WEST SUSSEX COUNTY COUNCIL CONSULTATION

TO:	Arun District Council FAO: James Cross
FROM:	WSCC - Highways Authority
DATE:	21 January 2020
LOCATION:	Langford, Horsemere Green Lane, Climping, BN17 5QZ
SUBJECT:	CM/64/19/PL Residential development comprising 1x3-bedroom bungalow, 2x3-bedroom houses, 2x2-bedroom houses 4x4-bedroom houses along with access and parking following demolition of existing dwelling - Departure from the Development Plan.
RECOMMENDATION:	Modification

Drawing Title:
SITE LAYOUT

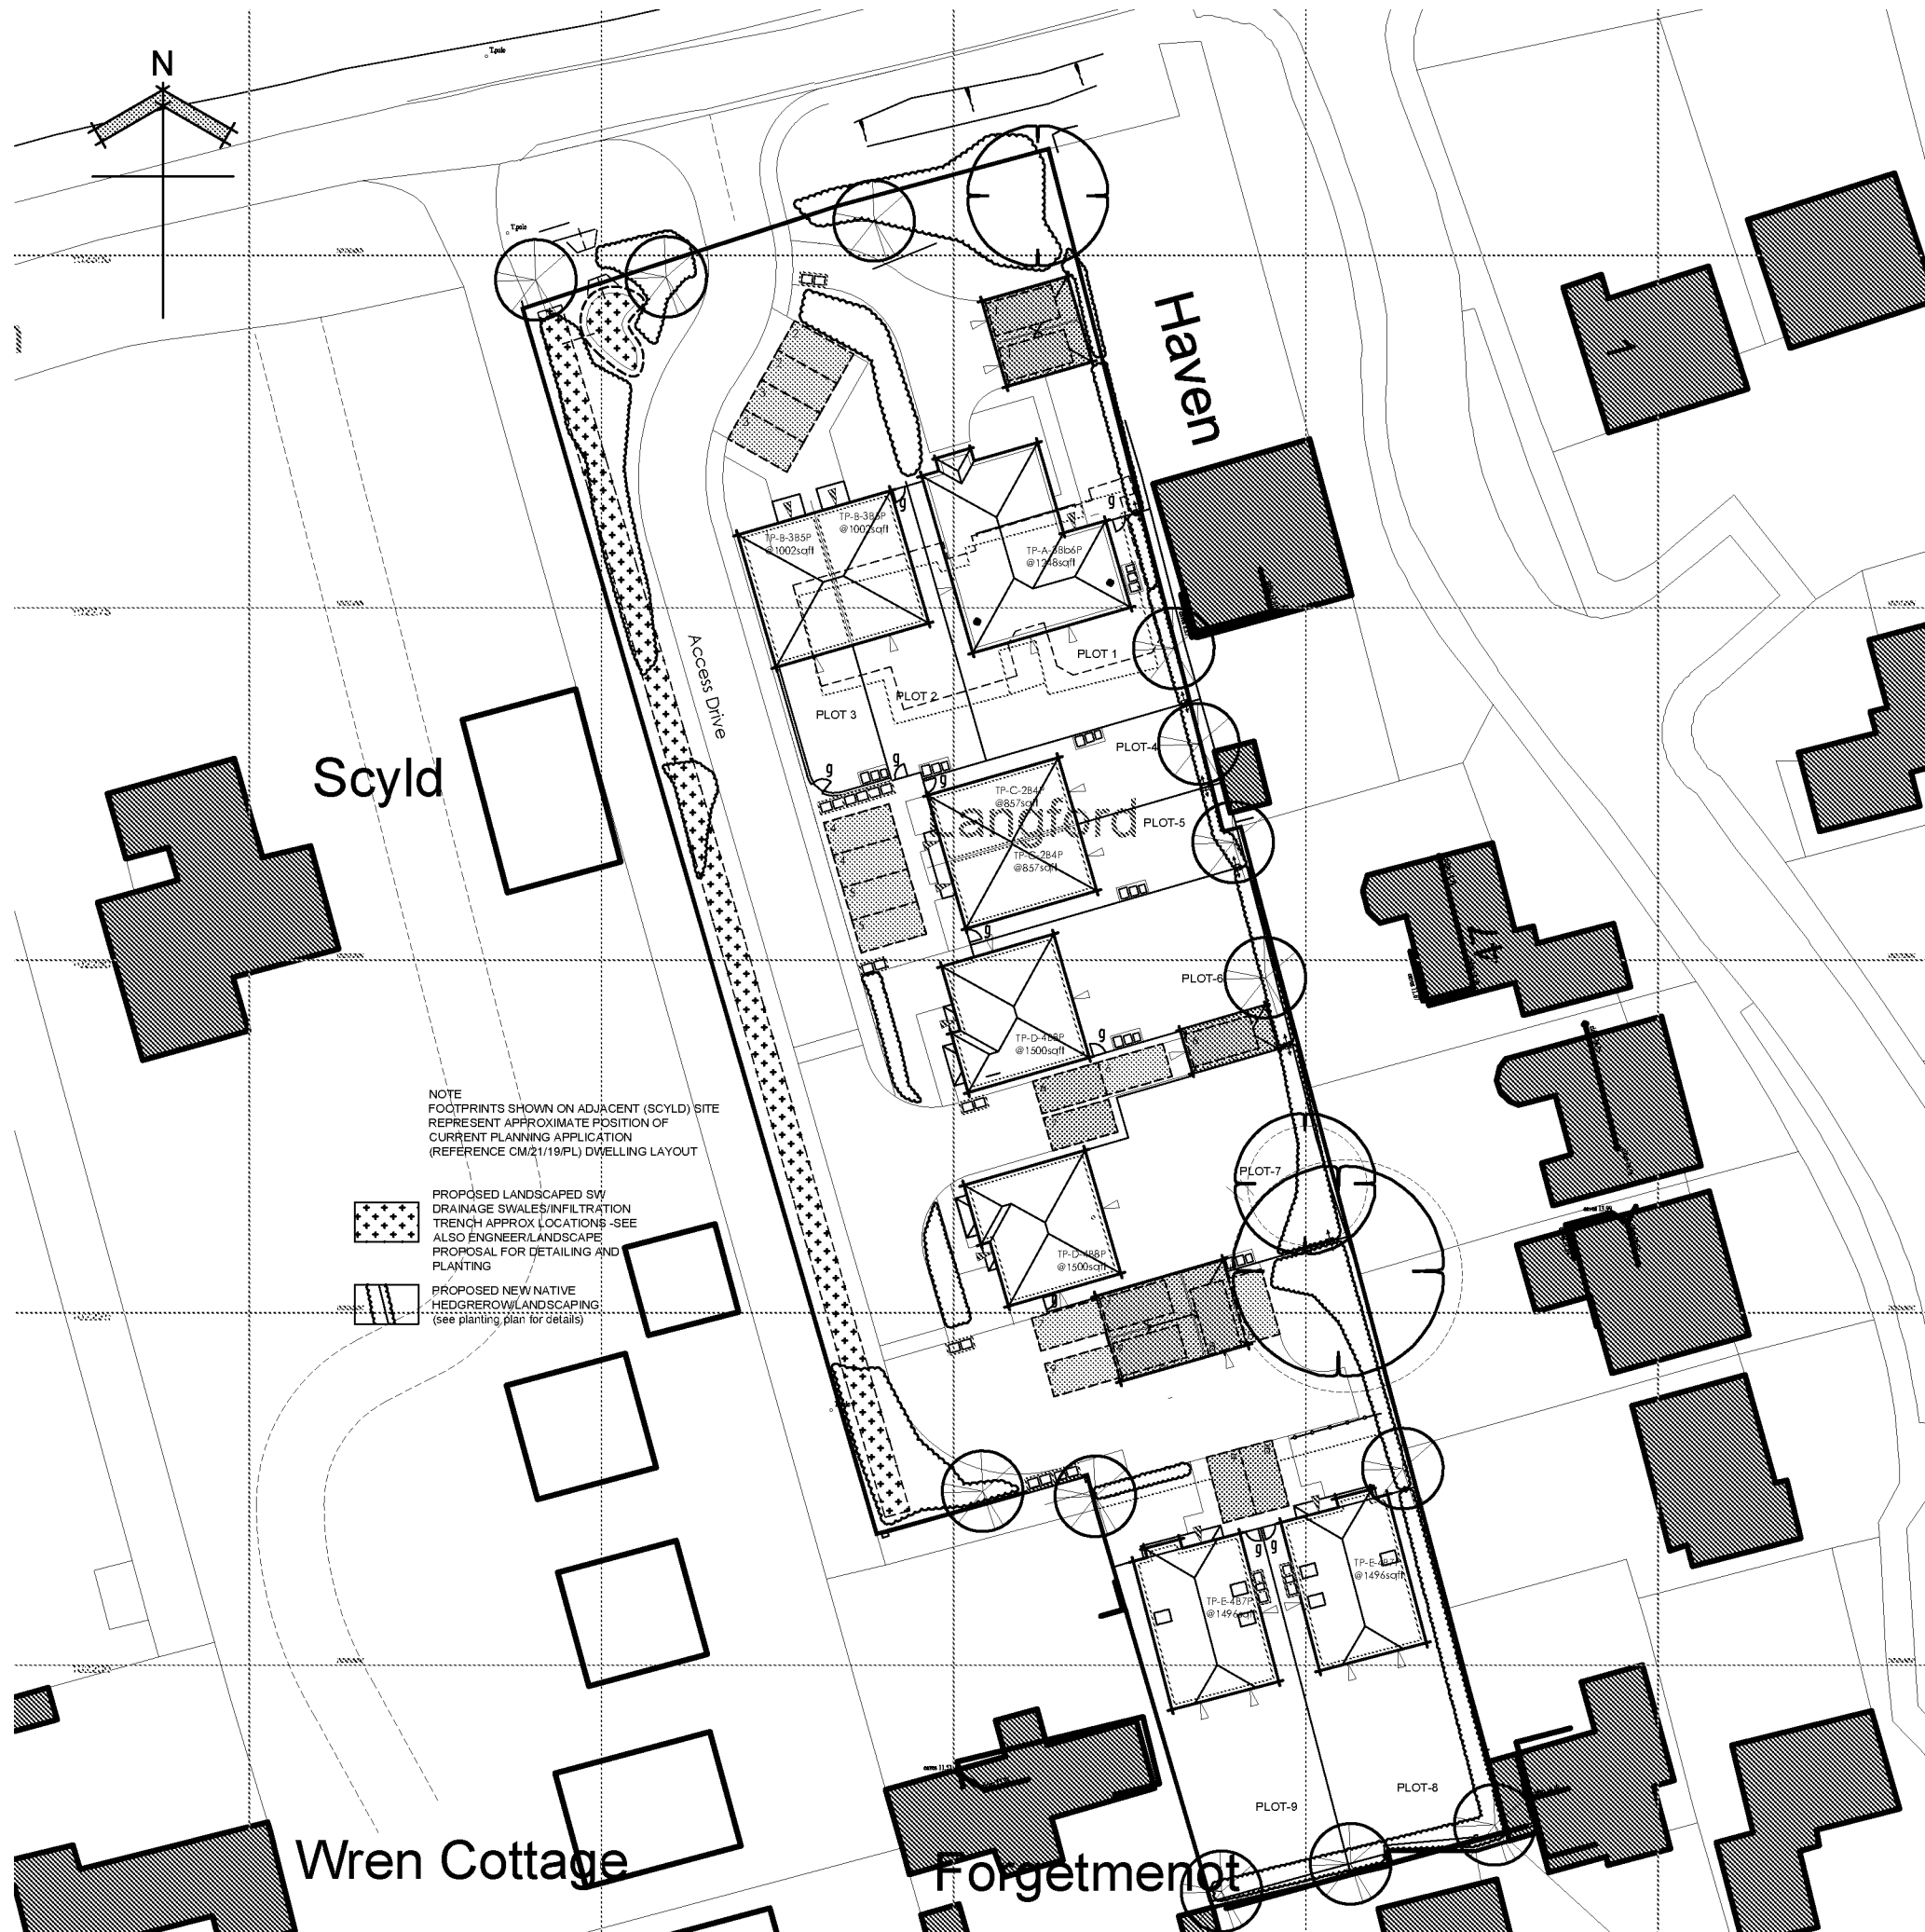
The indicative plans show an internal footway to segregate pedestrians from vehicular traffic. However, the footway appears to terminate at the site access (eastern side). It would be beneficial in terms of pedestrian safety and accessibility for the footway to continue along southern side of Horsemere Green Lane to link in with existing footway on junction of Appletree Walk/ Haven. This should be 2m wide footway and can be provided along with the access highway modification works (under agreement with WSCC Implementation team). There is existing footway across nearby junctions and a contribution was sought under the s106 agreement for CM/1/17 for additional footway on Horsemere Green Lane. In light of this it is considered that provision of small section of footway to tie in to existing pedestrian infrastructure network would be a suitable contribution from the developer to improve pedestrian accessibility of the site.

In summary the principle of residential development is acceptable and not anticipated to result in highway safety or capacity concerns. Nevertheless, the applicant should consider providing additional visitor car parking and electric vehicle charging infrastructure. They should also demonstrate new section of footway along Horsemere Green Lane linking the site access to Appletree Walk.

Drg No: 190725/SL-02 Rev: C

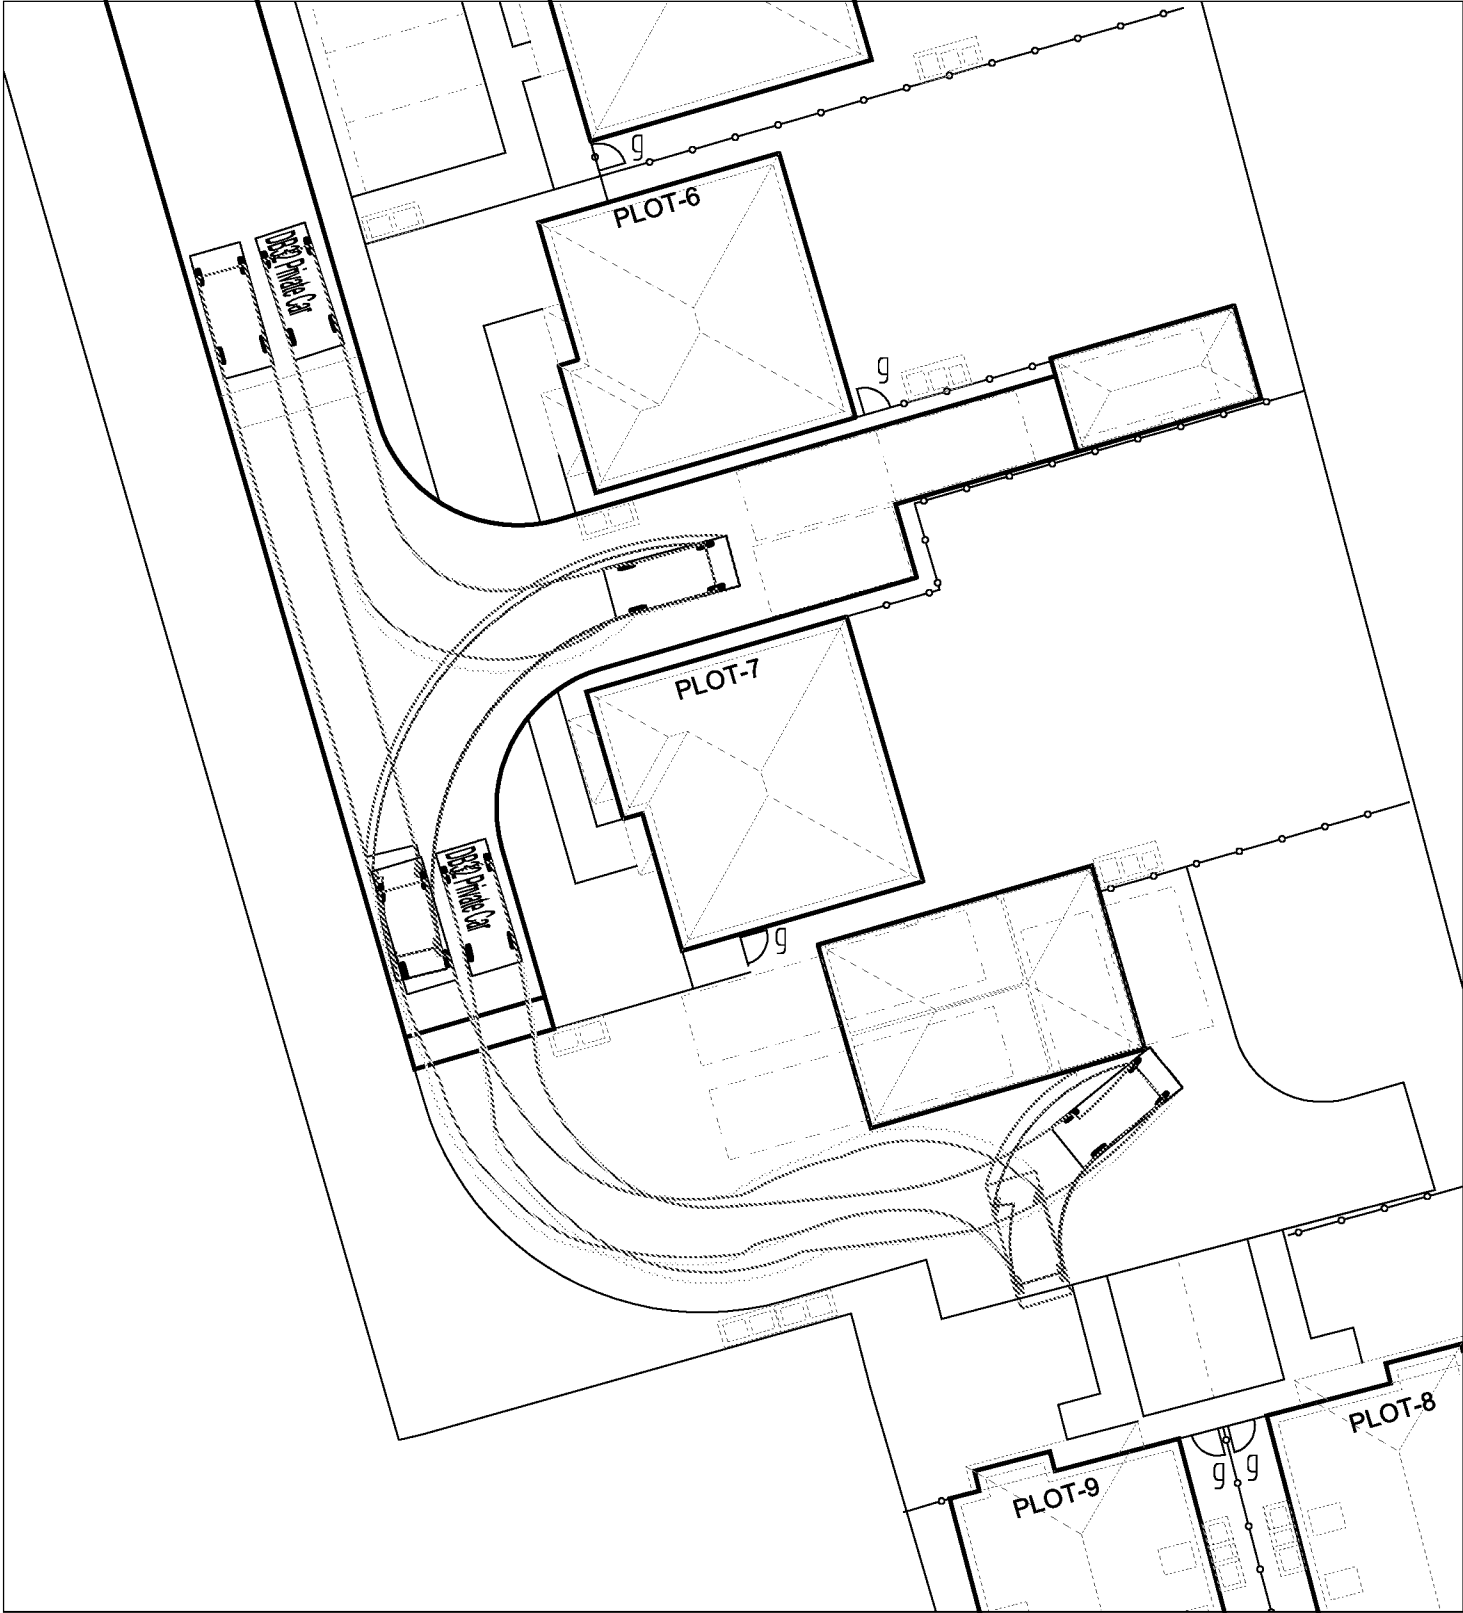
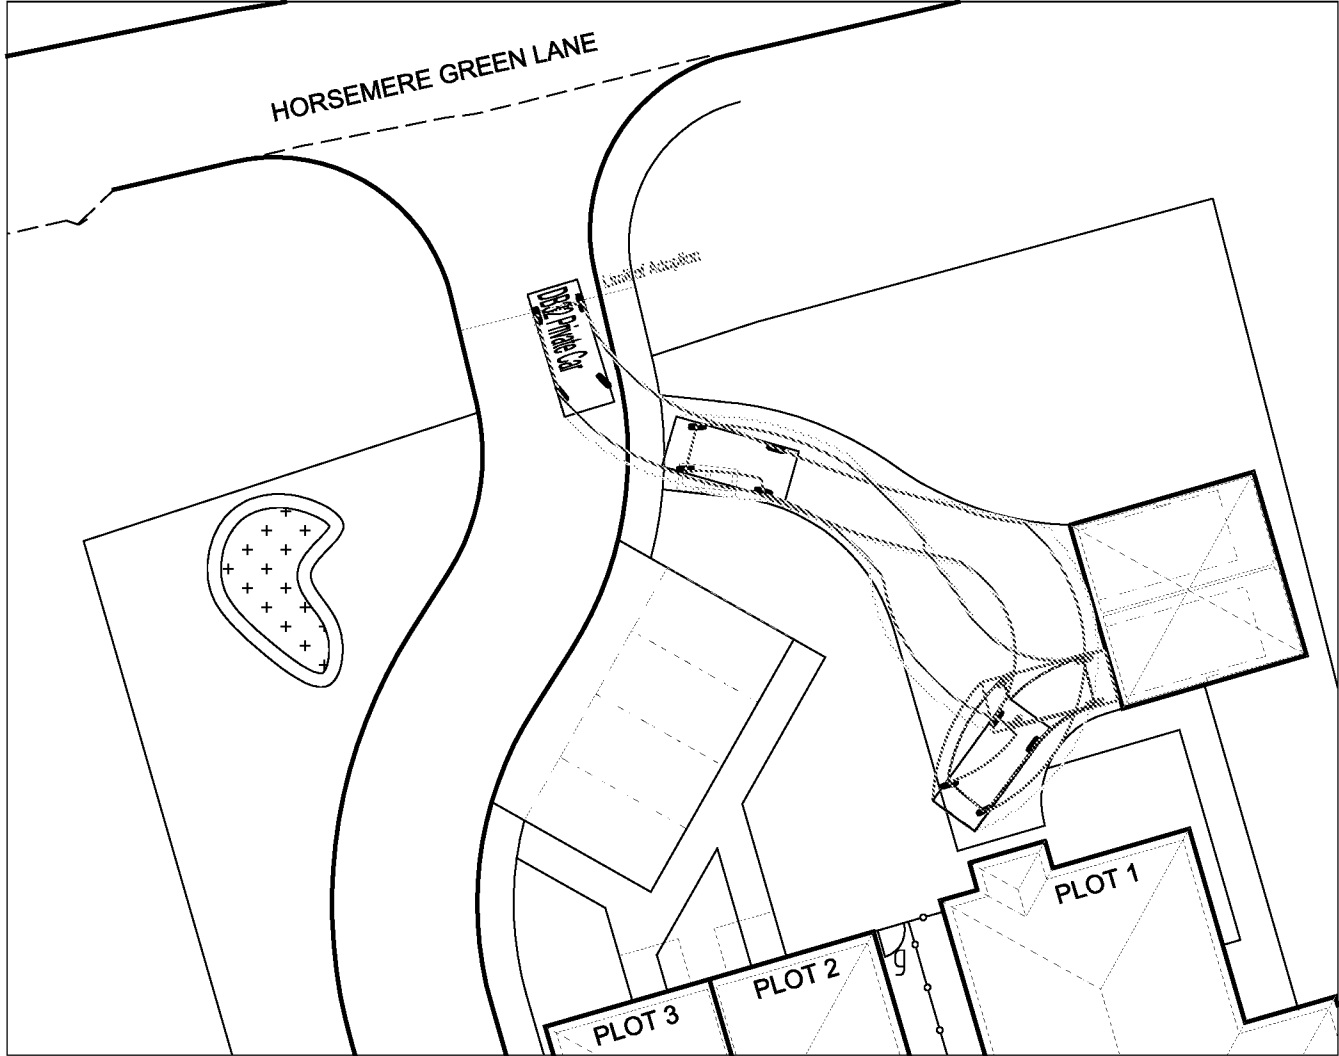
The Parking Strategy Plan indicates that a total of 22 x allocated car parking spaces will be provided across the development. This is based on 3 x spaces per 4-bedroom and 2 x spaces per 3-bedroom and 2-bedroom unit. This is inline with parking provision requirements set out in the Arun District Council Supplementary Planning Document (SPD), due to the rural location. The SPD also sets out that visitor parking should be provided at a rate of 20% of total number of units. On this basis, an additional 2 x visitor car parking spaces should be provided and the applicant should consider provision of this. The applicant should also consider providing electric vehicle charging points, for example within the proposed car barns.
